D-49 Transportation Center Traffic Impact Study

OCTOBER 12, 2021

LSC #S214340

Summary of Comments on LSC Responses to EPC TIS Redline comments.pdf

Figure 2
Proposed Site and Access Plan
 D49 Transportation Facility - Falcon (LSC #S214340)

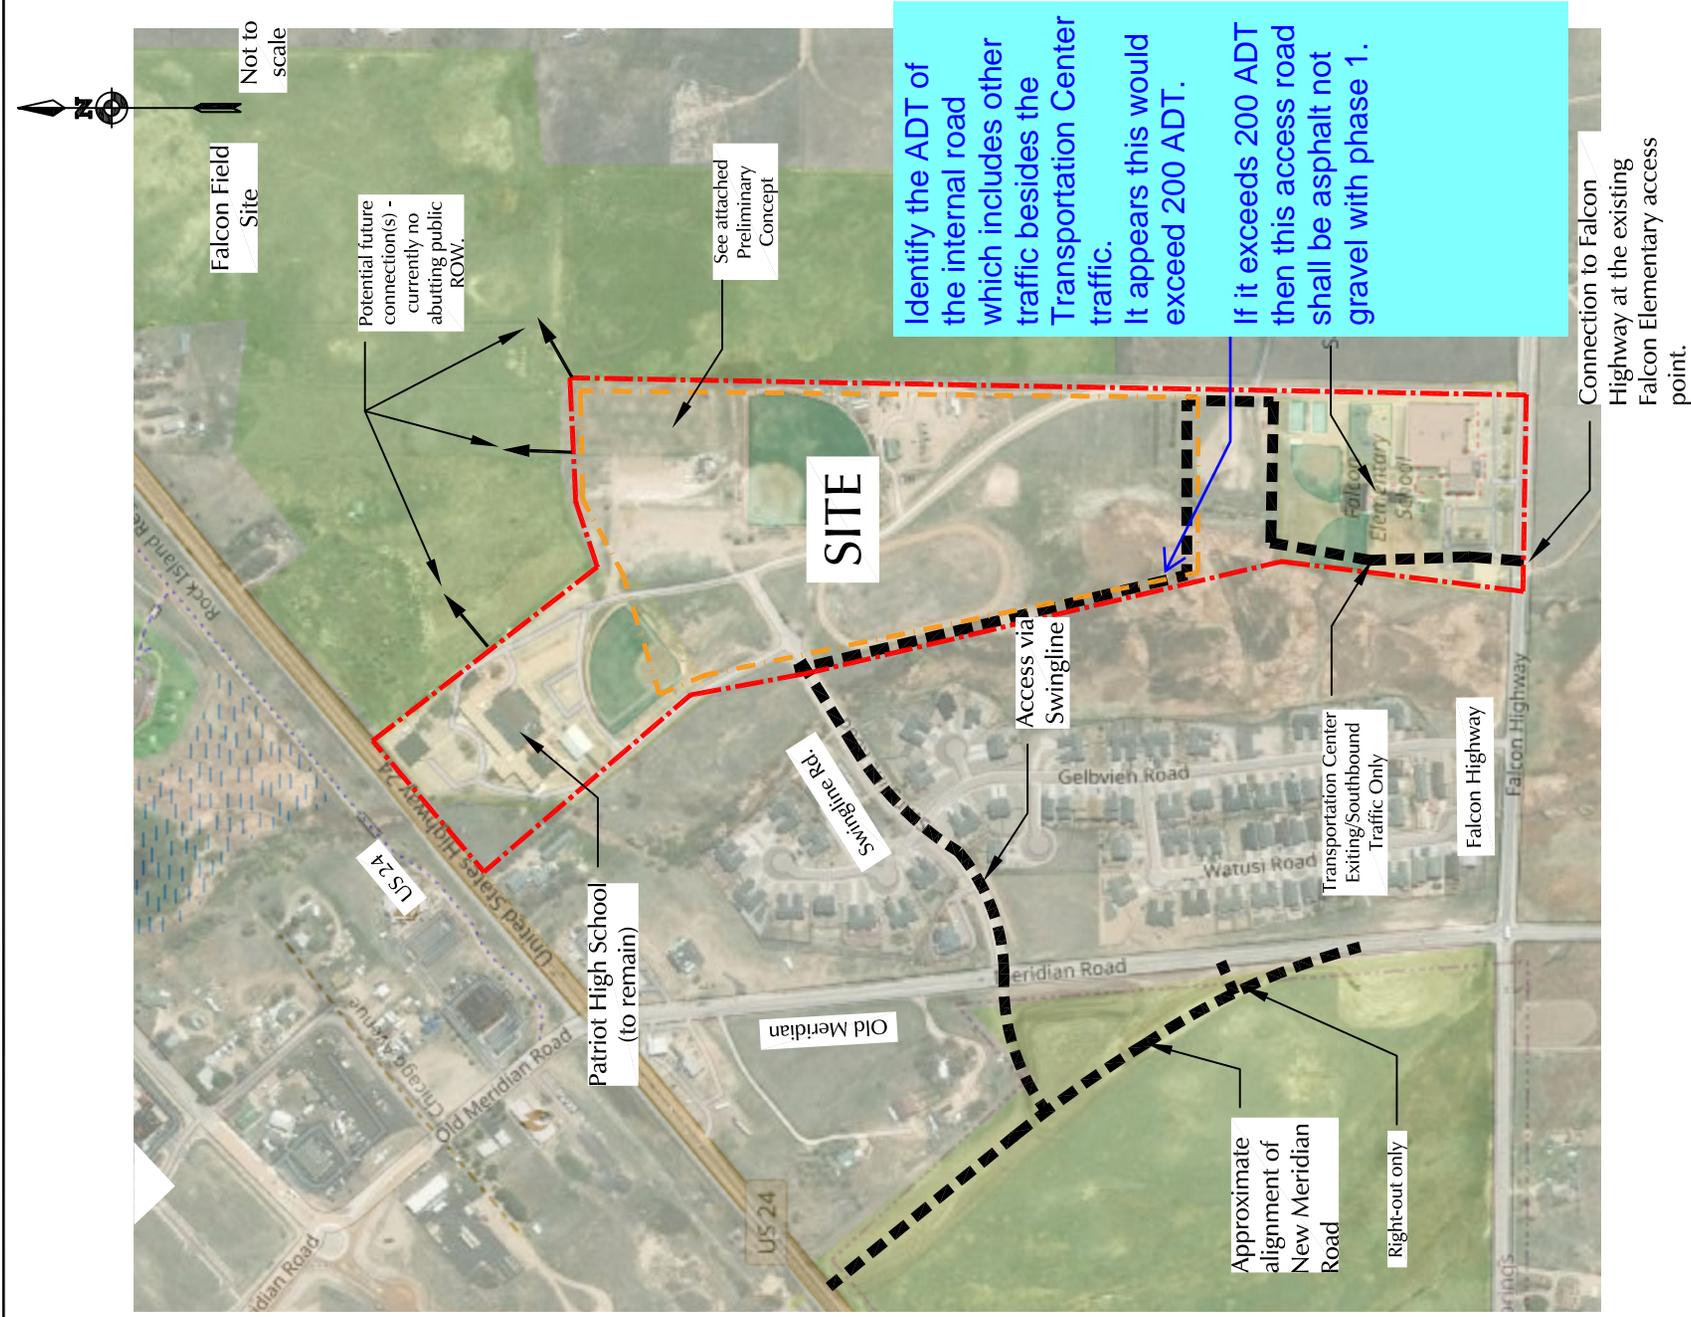
Will all outbound traffic use the Falcon Hwy access?

No, outbound traffic will use Falcon Hwy and Swingline. A third outlet to Hwy 24 is part of future planning.

Figure 4
West Access* Sight Distance
D49 Transportation Facility (LSC# S214340)

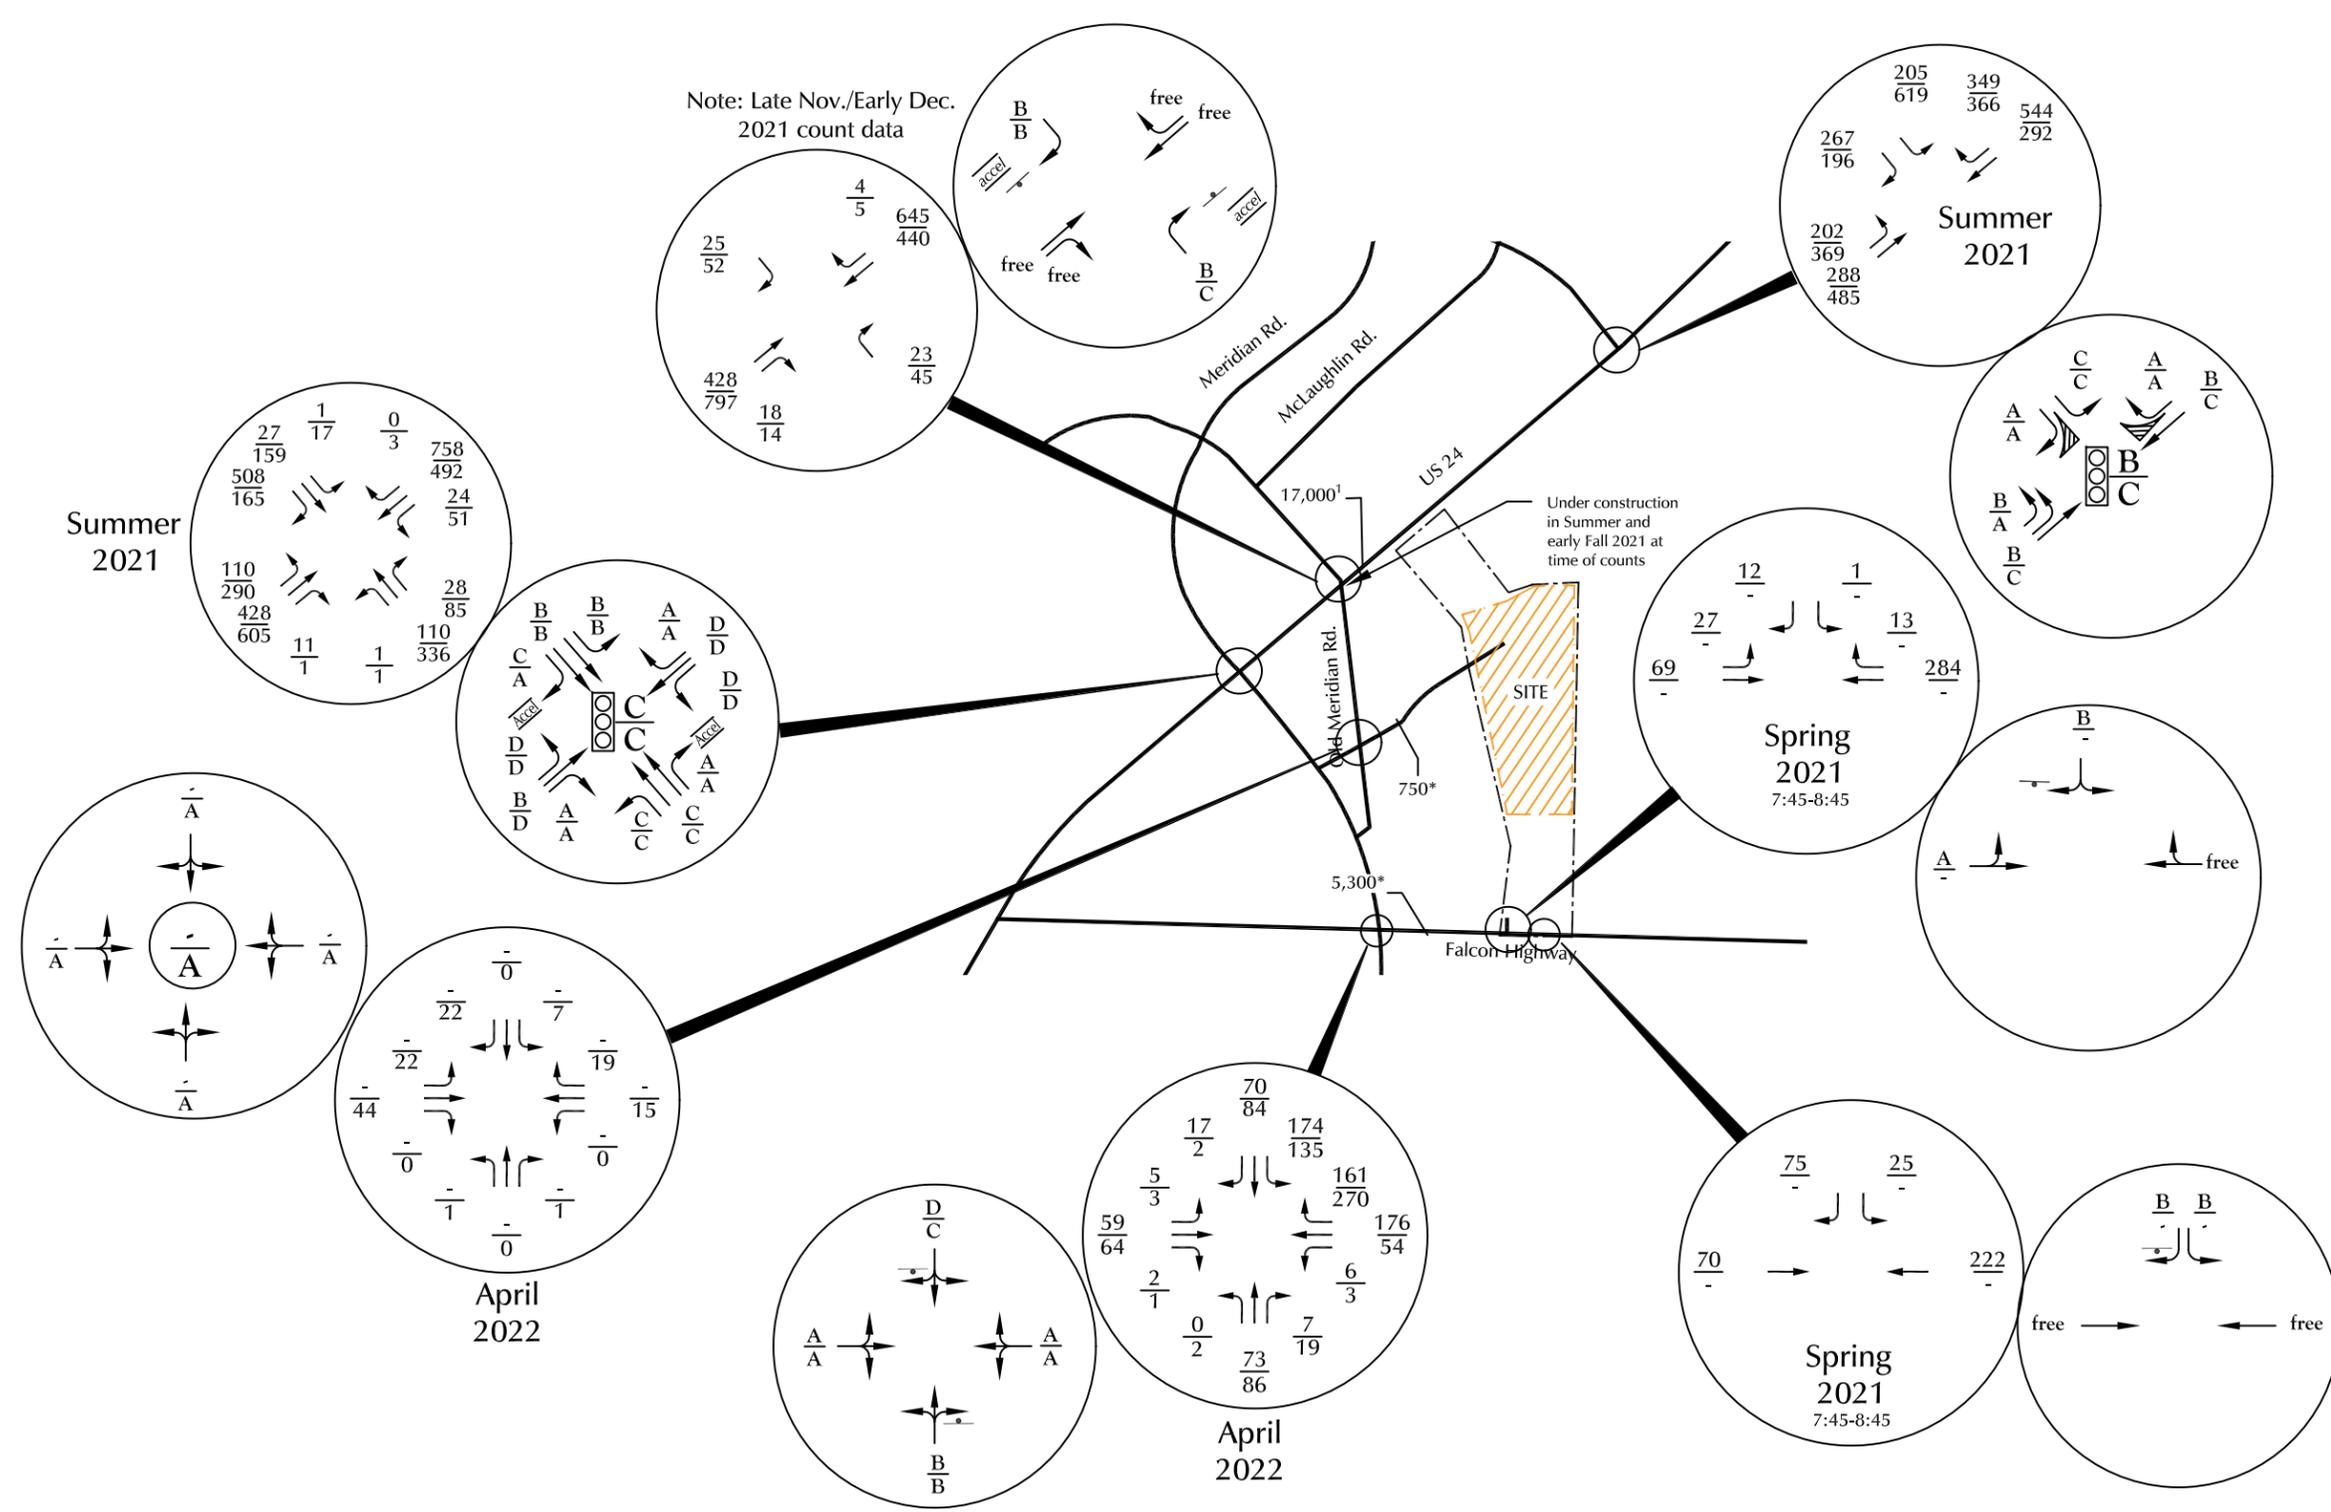
Please provide an exhibit with sight distance lines for both design vehicles.

These have been added to the TIS report as requested.
